Our ref: Winterbourne Wind Farm (SSD-10471)

18 August 2025

Subject: Request for Additional Information

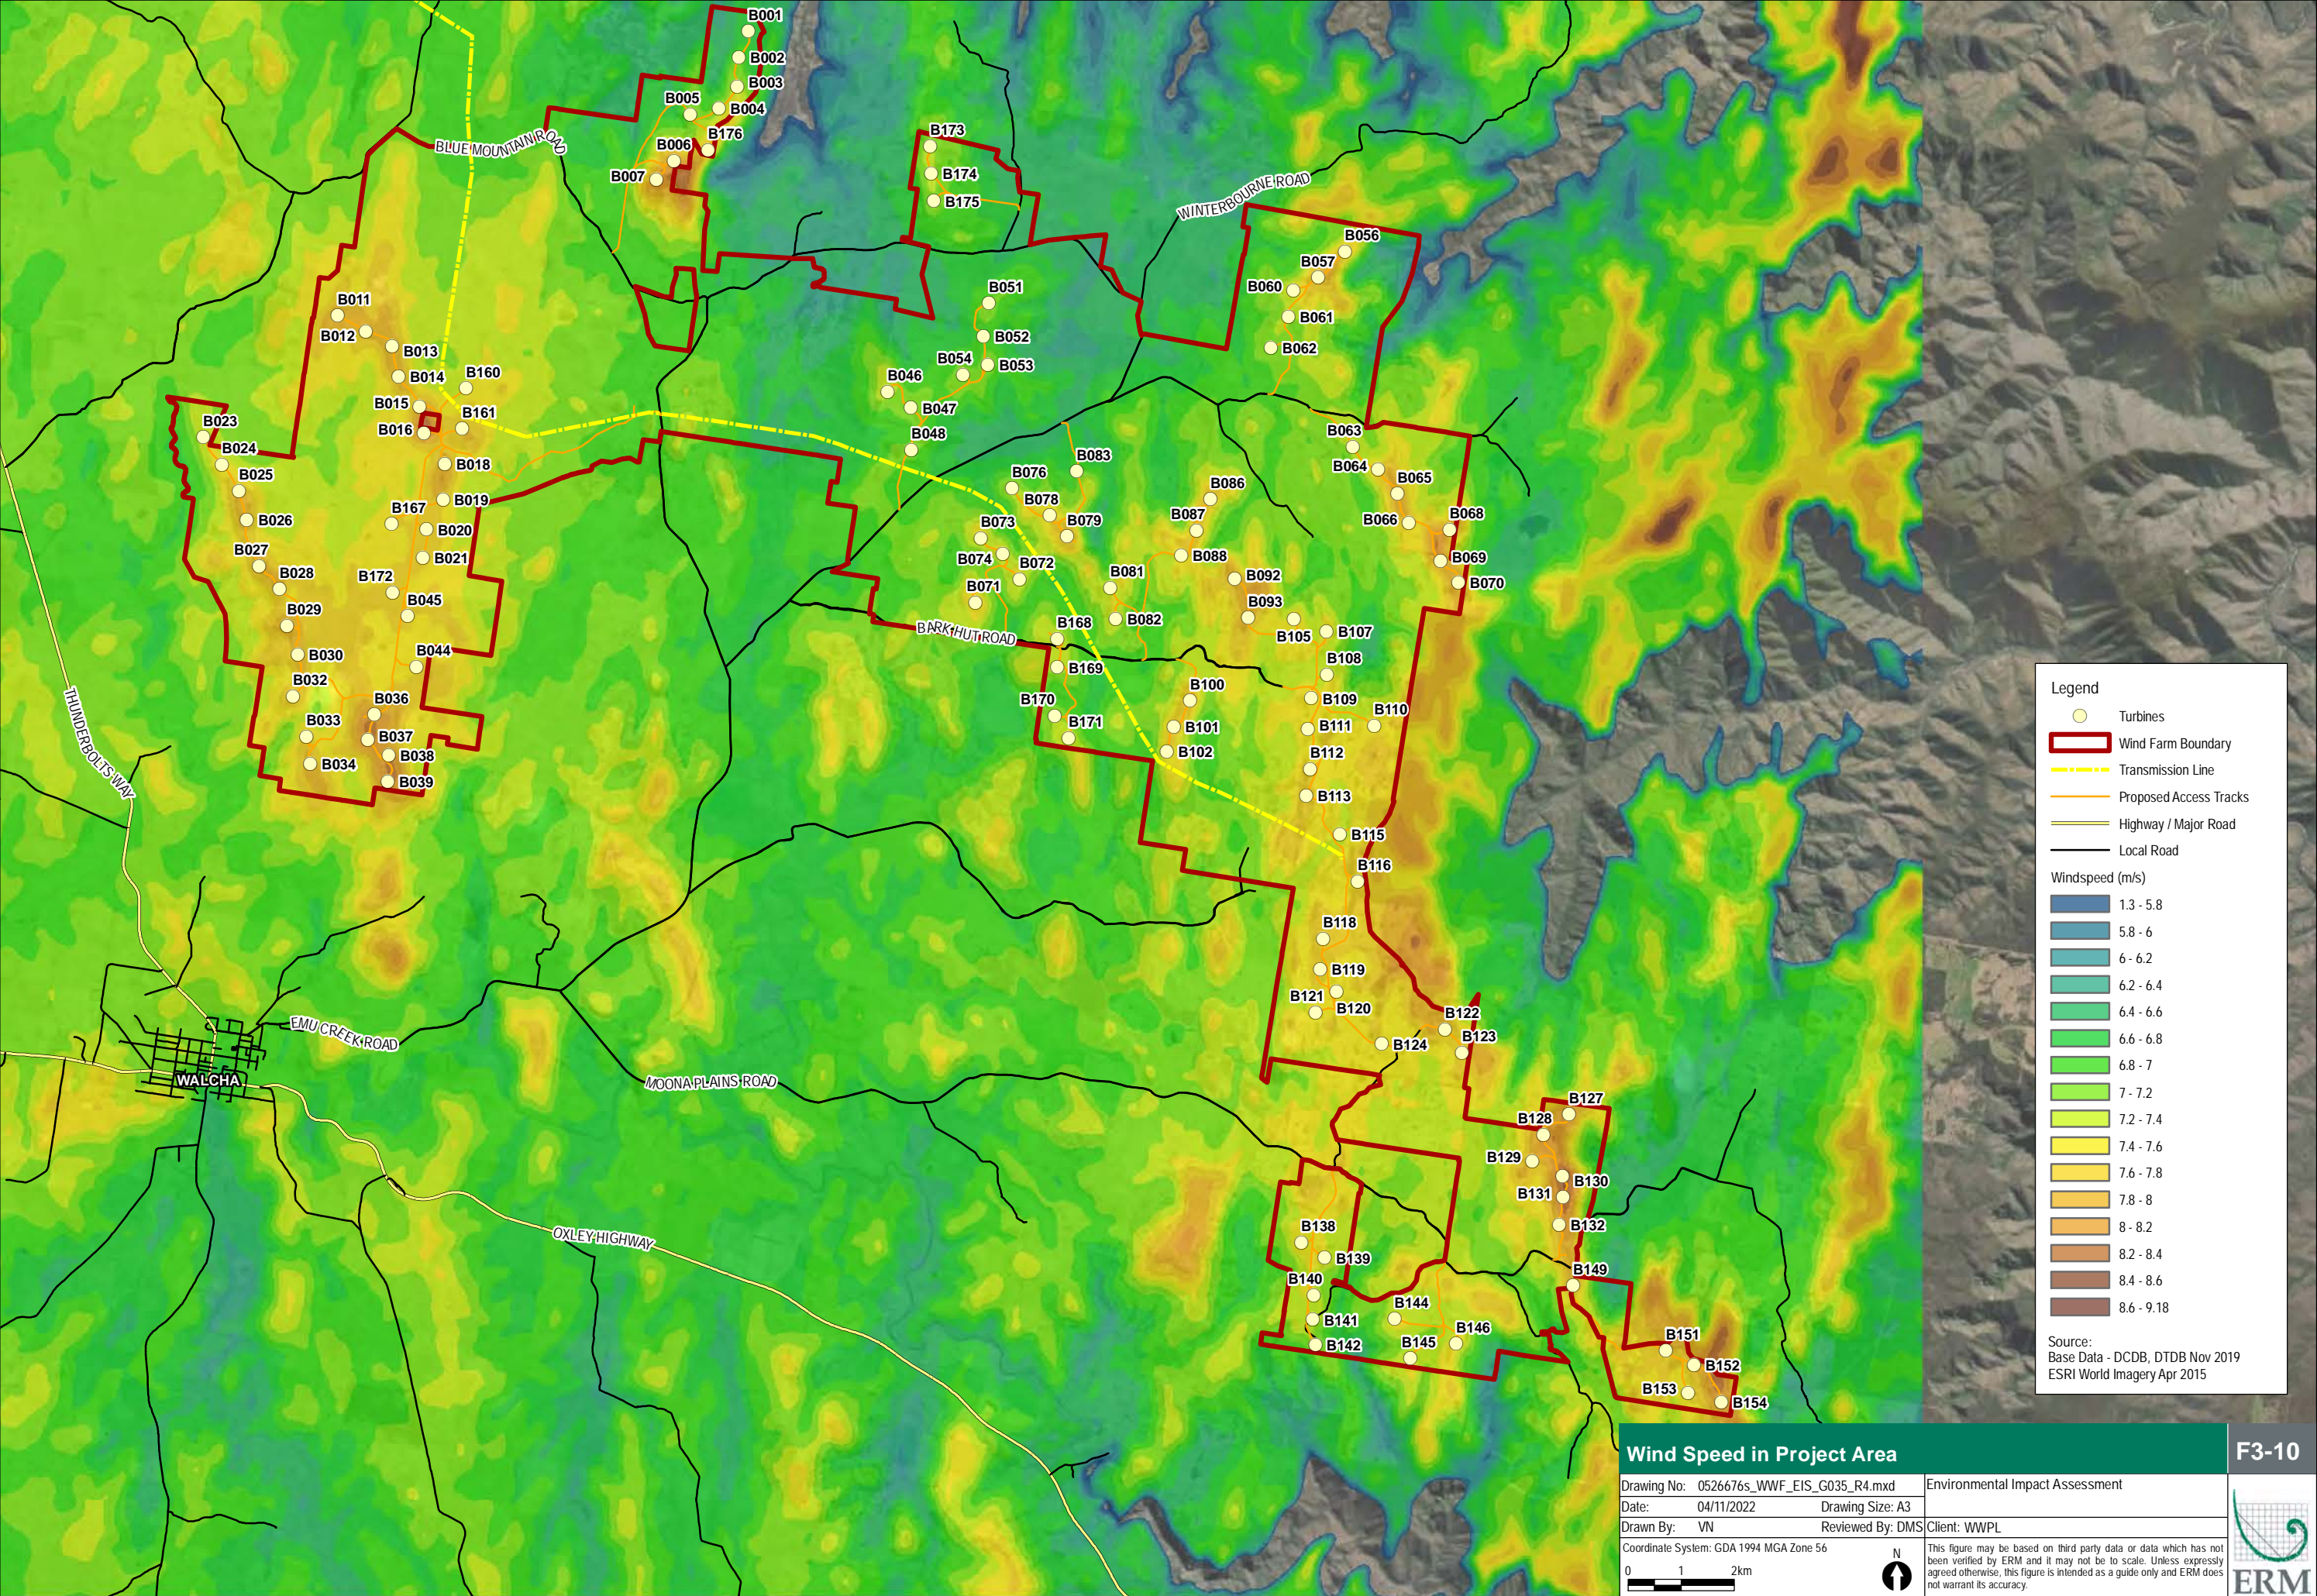
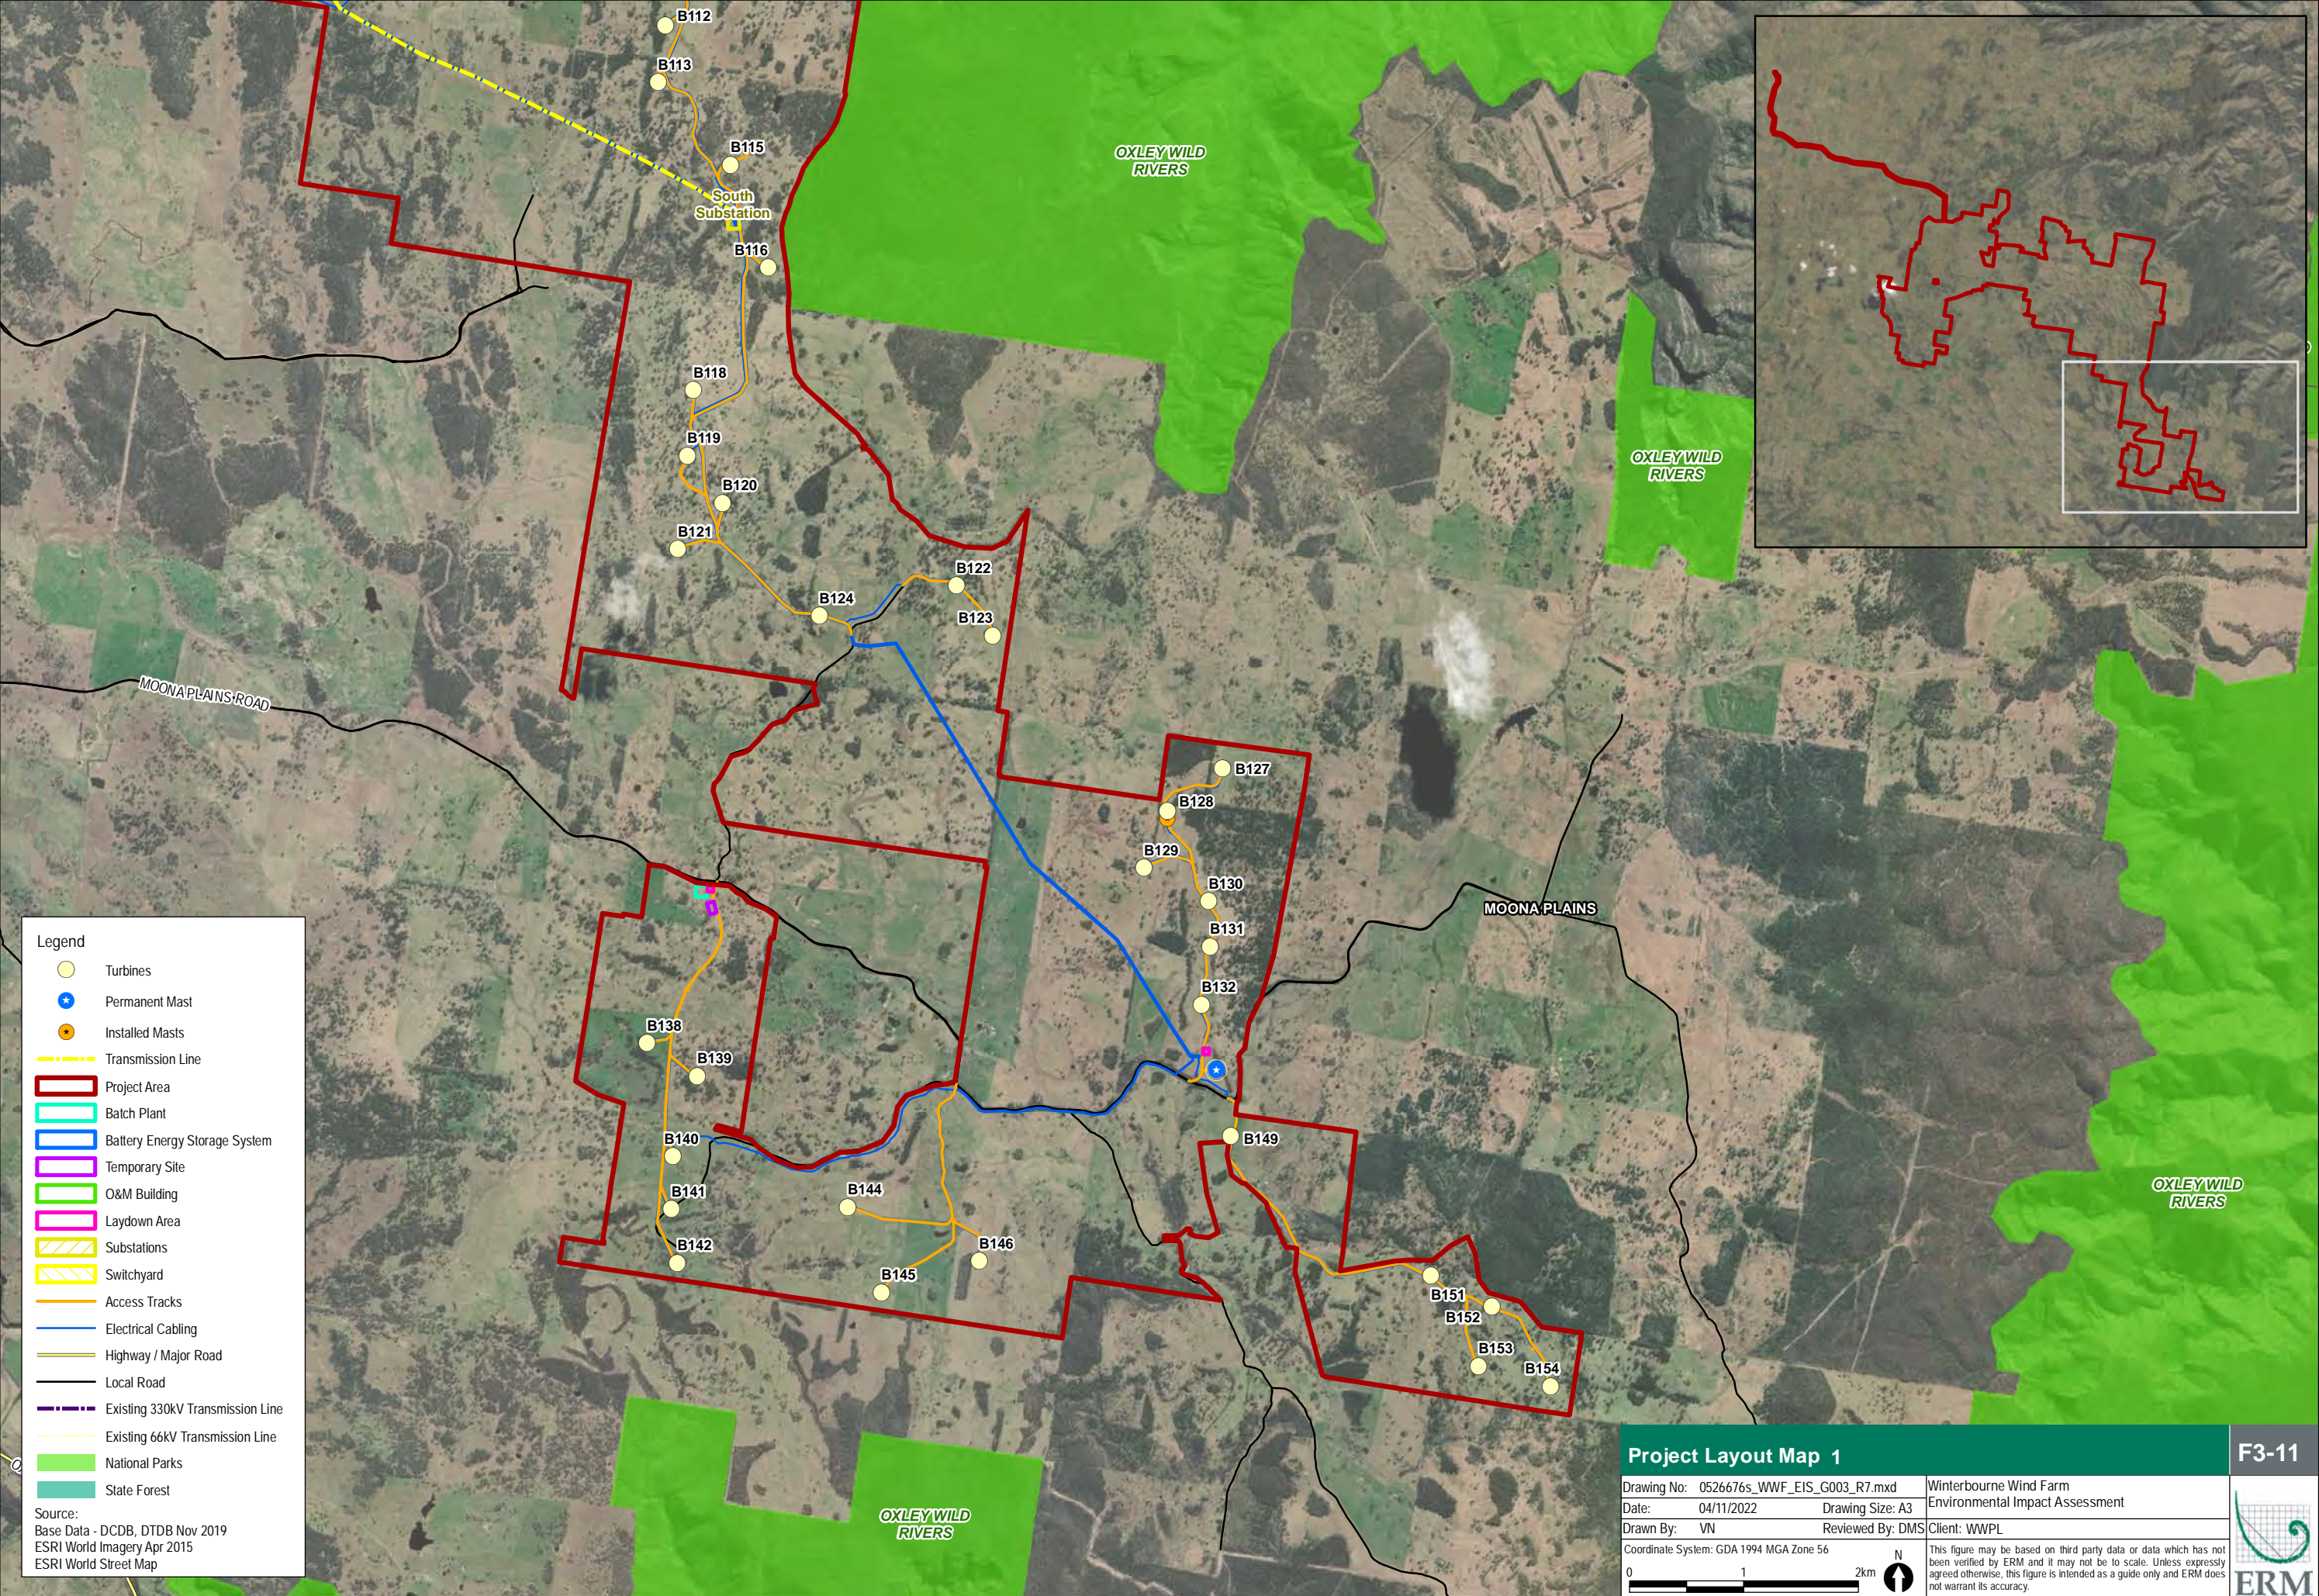
| Item | Comments |
|-----------------------|---|
| Traffic and Transport | <ul style="list-style-type: none"> Provide details of all proposed road and/or intersection upgrade works. Provide landowners consent for all land parcels facilitating the proposed road upgrades. |

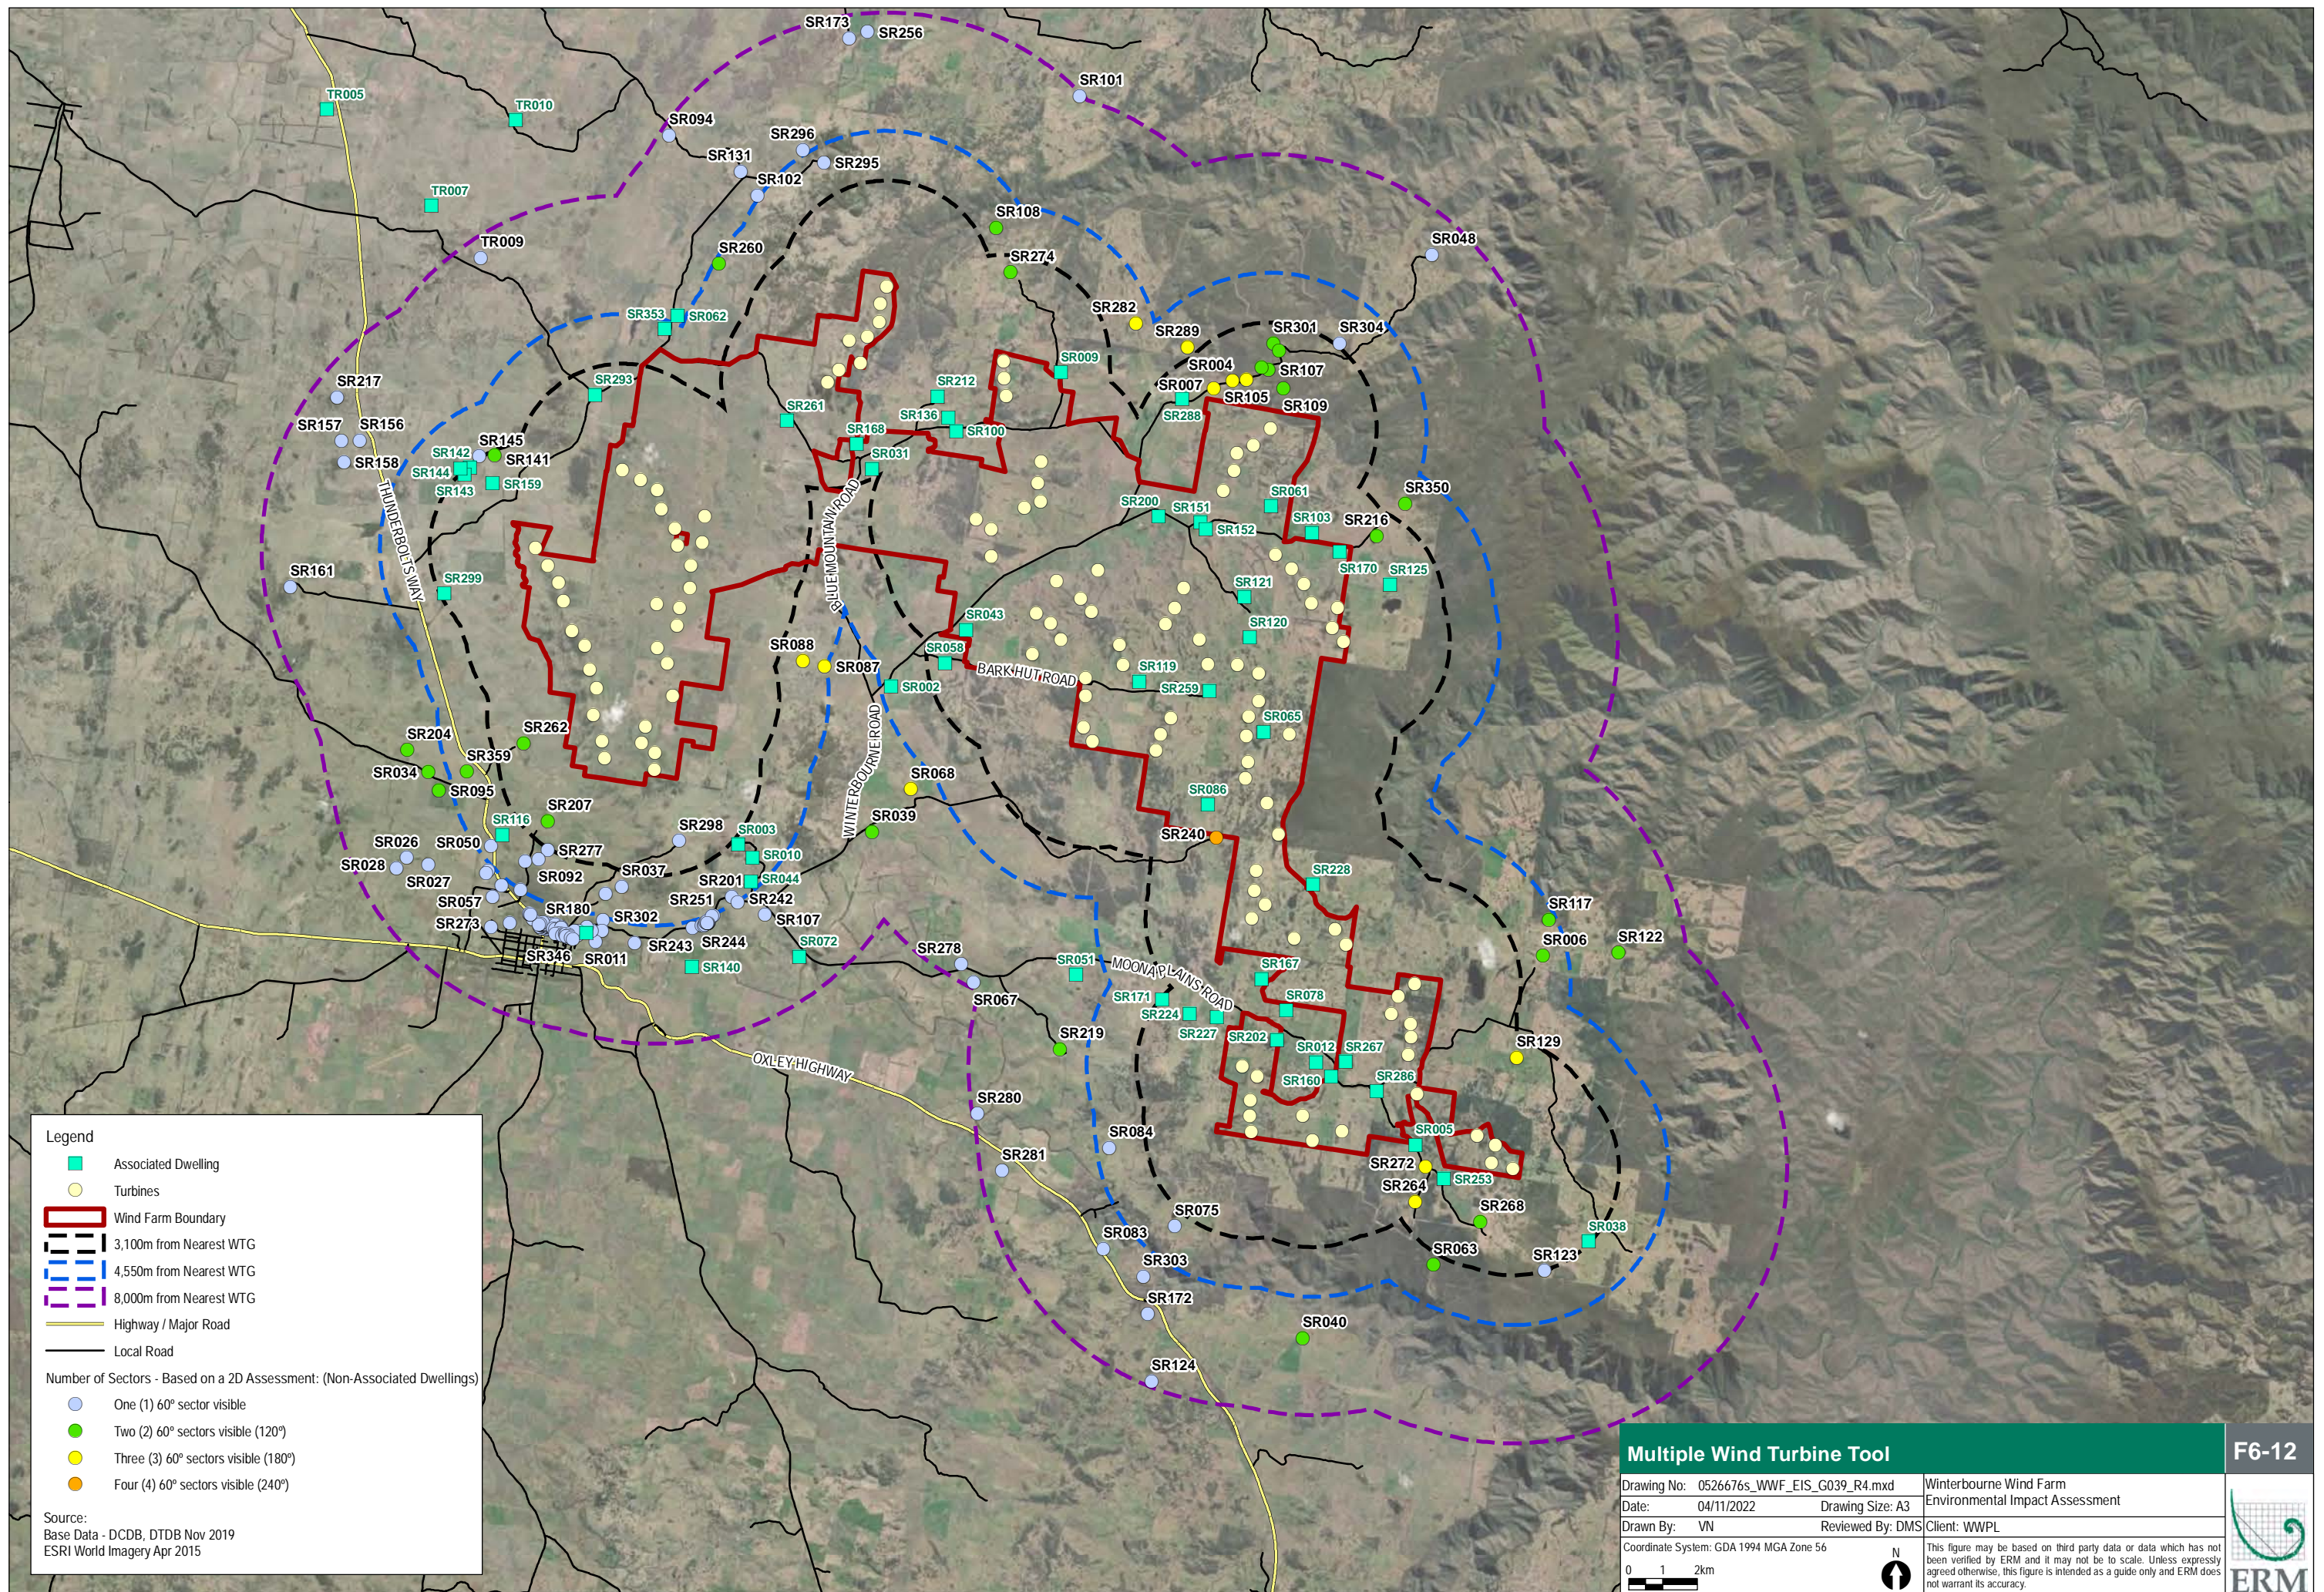
| Item | Comments |
|-----------------------|---|
| Visual | <ul style="list-style-type: none"> Confirm whether SR224 is associated with the project, as there is inconsistency in the presentation of this receiver in the Amendment Report dated 3 October 2024. If SR224 is a non-associated dwelling, provide a detailed assessment in accordance with the NSW Wind Energy Framework, including the Visual Assessment Bulletin (DPE, 2016). Provide a wifeframe with existing vegetation rendered based on LiDAR data for non-associated dwellings SR208, SR216, SR298 and SR300. Provide a consolidated spreadsheet of all receivers and their status (associated or non-associated) and the distance between each turbine for receivers within the black line, between the black and blue line and within 8km. Provide confirmation of the photomontage assessment methodology for receiver SR007. Provide confirmation of the maximum shadow flicker hours likely to be experienced at receivers SR004, SR007, SR240, SR272 and SR262 and proposed mitigation details. |
